## REFUSAL OF PLANNING PERMISSION

**APPLICATION NO:** 3/2013/0321

**DEVELOPMENT PROPOSED:** Proposed construction of single storey side extension to provide improved living and bedroom space. Amended re-submission.

**AT:** Slimrow Slaidburn Road Newton-in-Bowland Lancashire BB7 3DL

Drawing Title
PROPOSED PLAN & ELEVATIONS

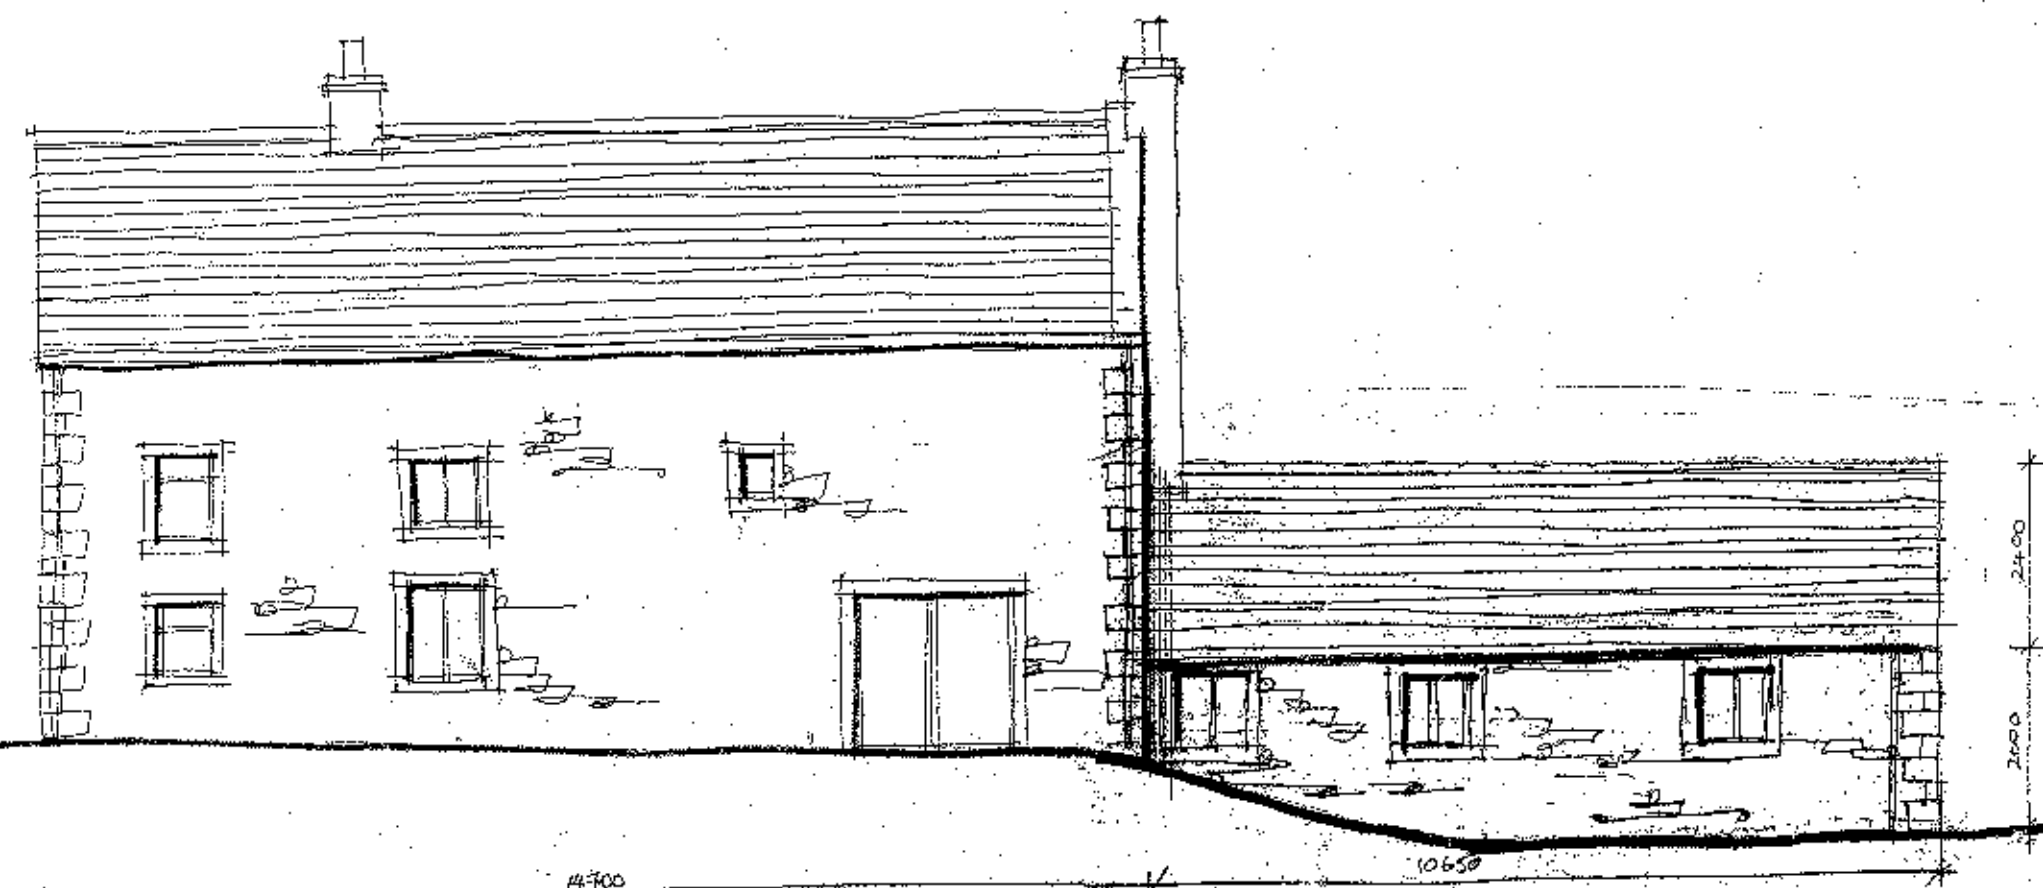
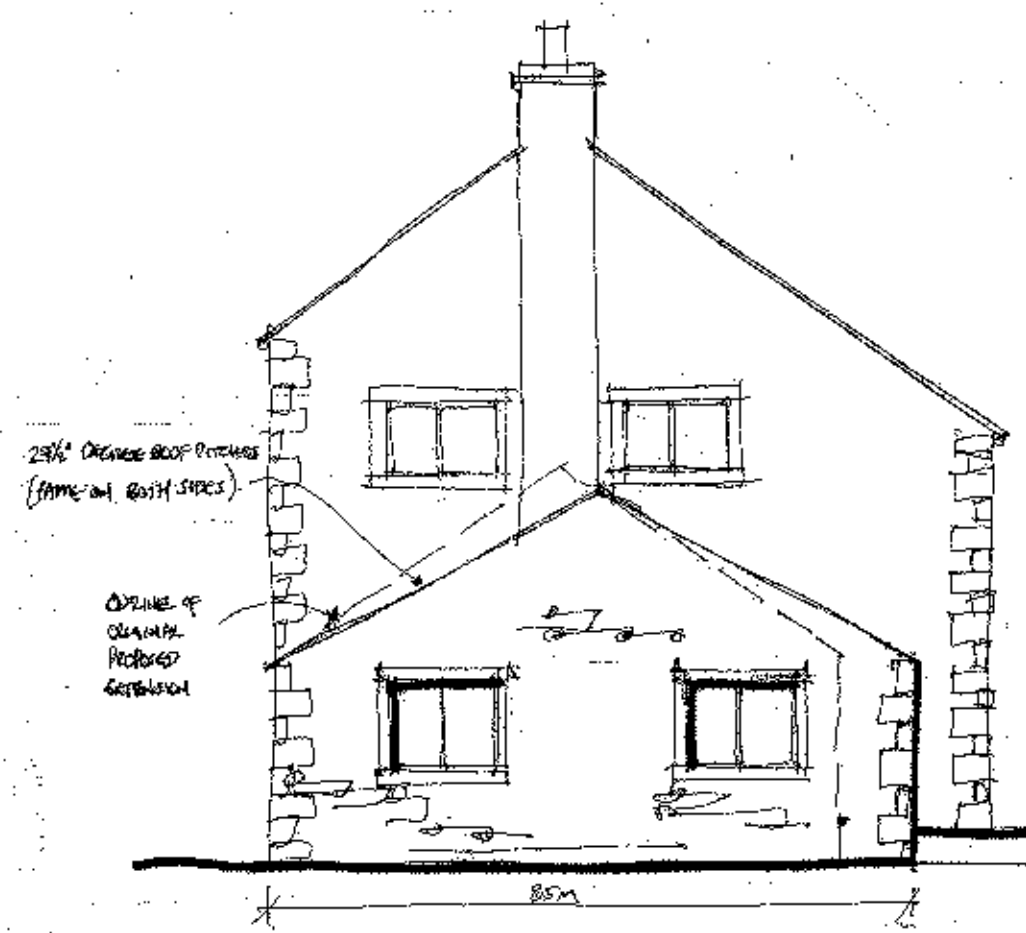
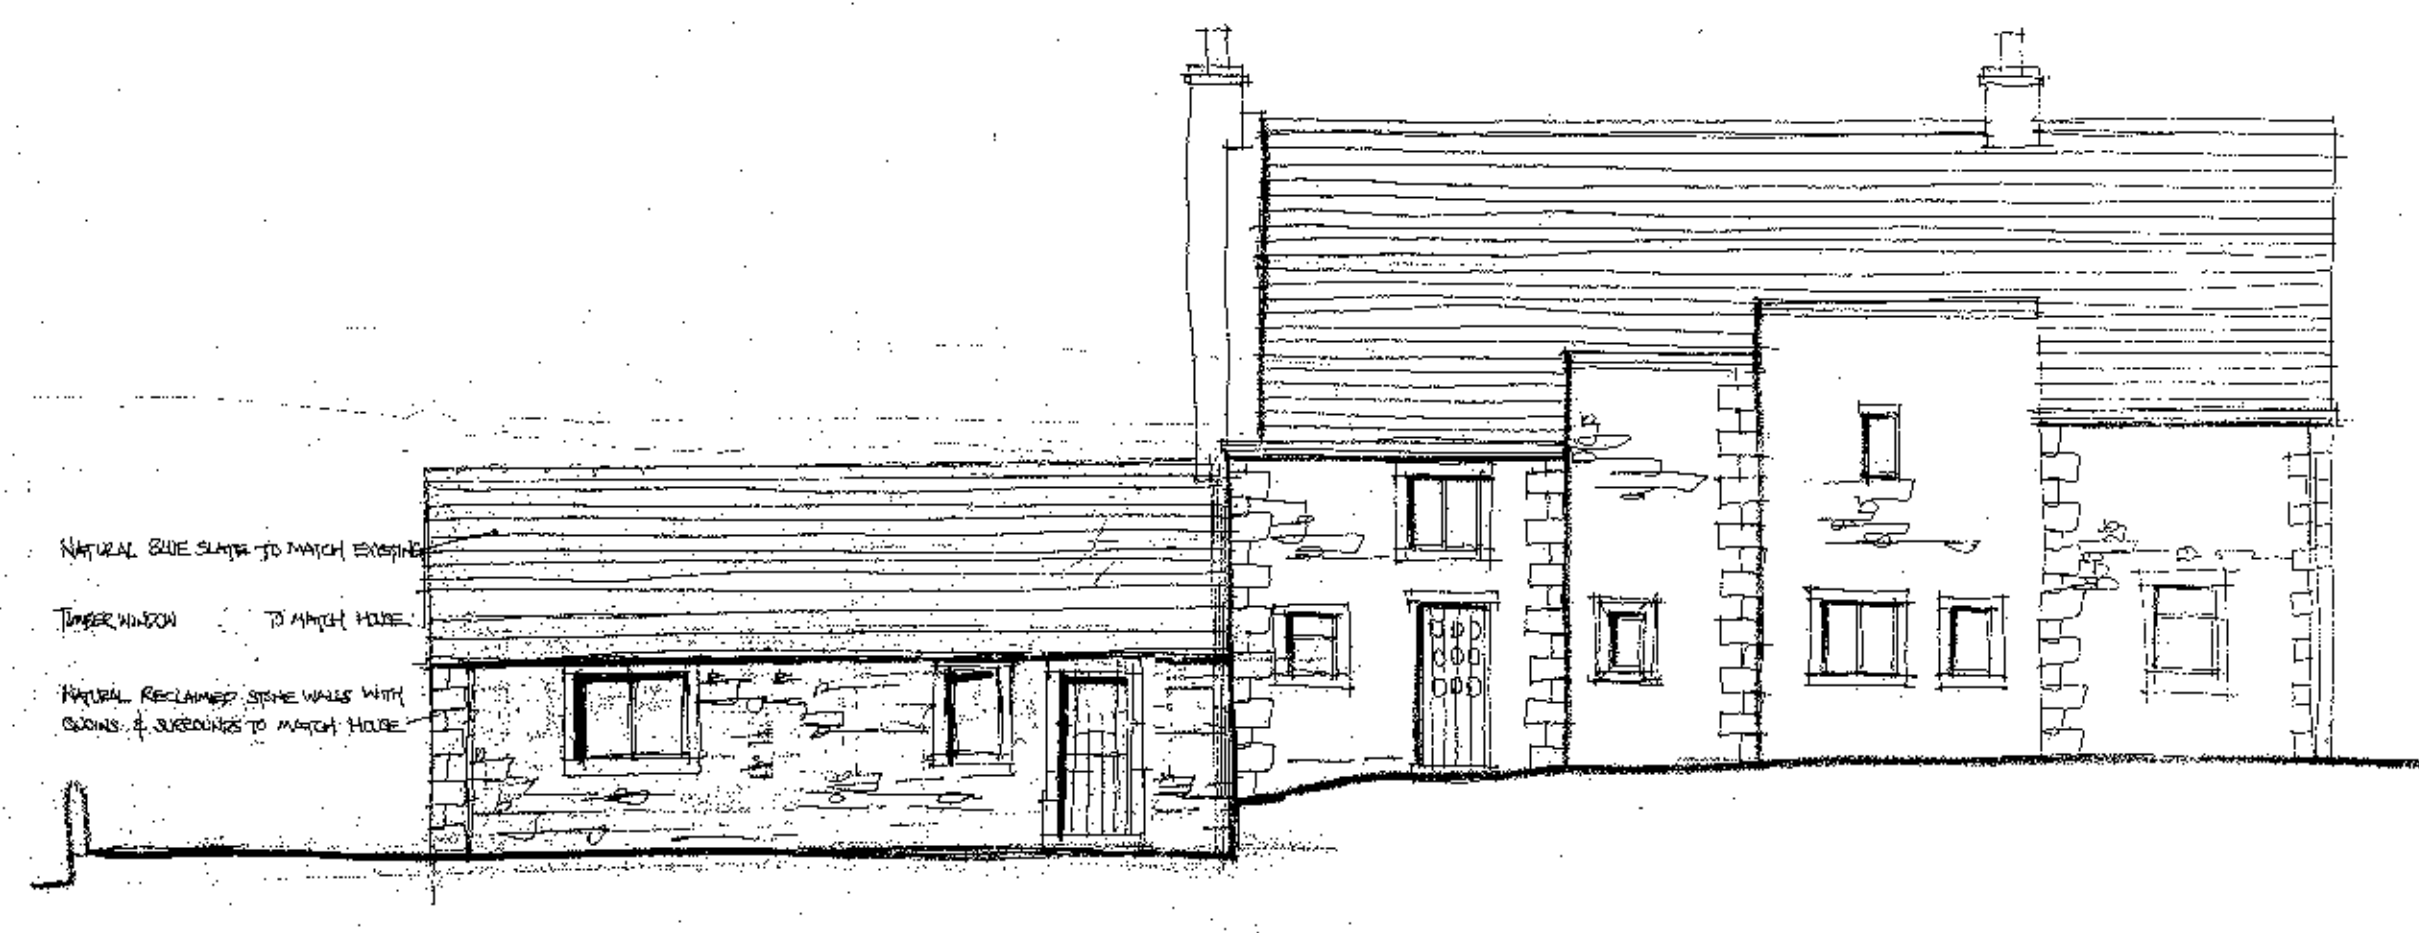
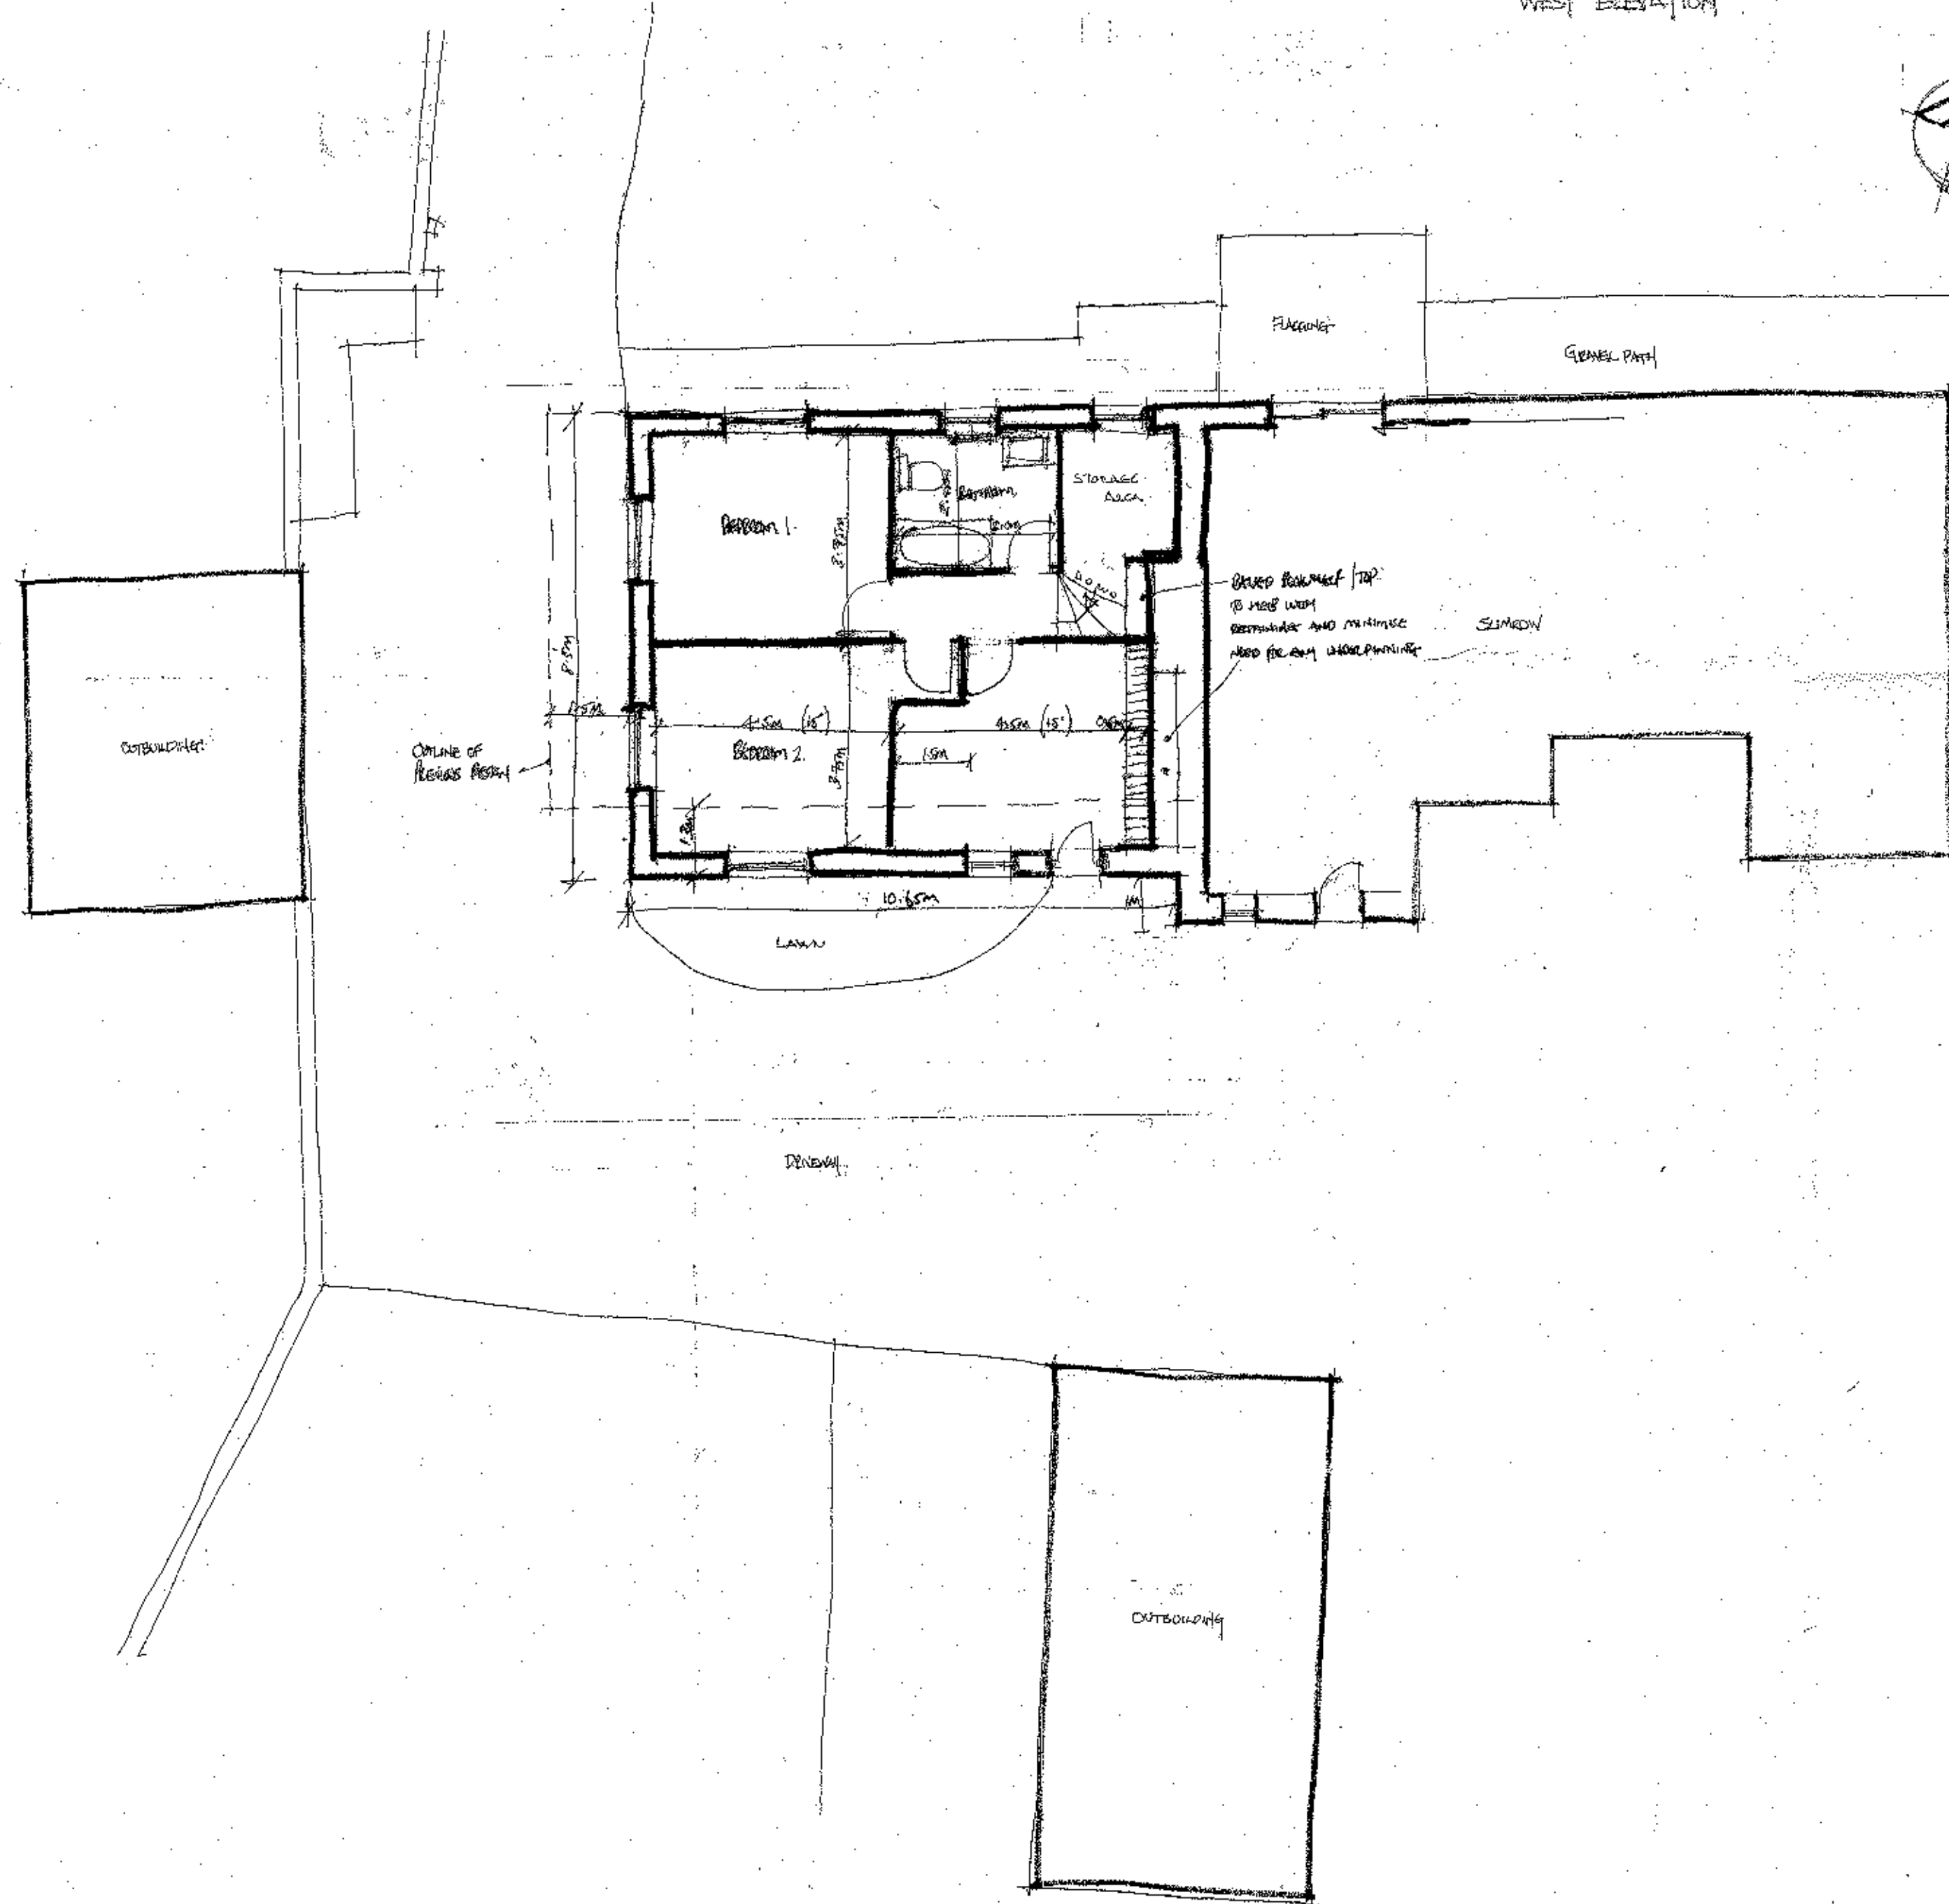
- 1 It is the opinion of the Local Planning Authority that the proposed development would by virtue of its size, massing and bulk represent an incongruous and unsympathetic addition to the existing dwelling. It is considered that this would be detrimental to the character, setting and visual amenities of the Forest of Bowland AONB. This would be contrary to; Policies G1, ENV1 and H10 of the Ribble Valley Districtwide Local Plan, Policies DMG1, DME2 and DMH5 of the Ribble Valley Core Strategy 2008-2028 (Regulation 22 Submission Draft) and the Council's adopted SPG on Extensions and Alterations to Dwellings.
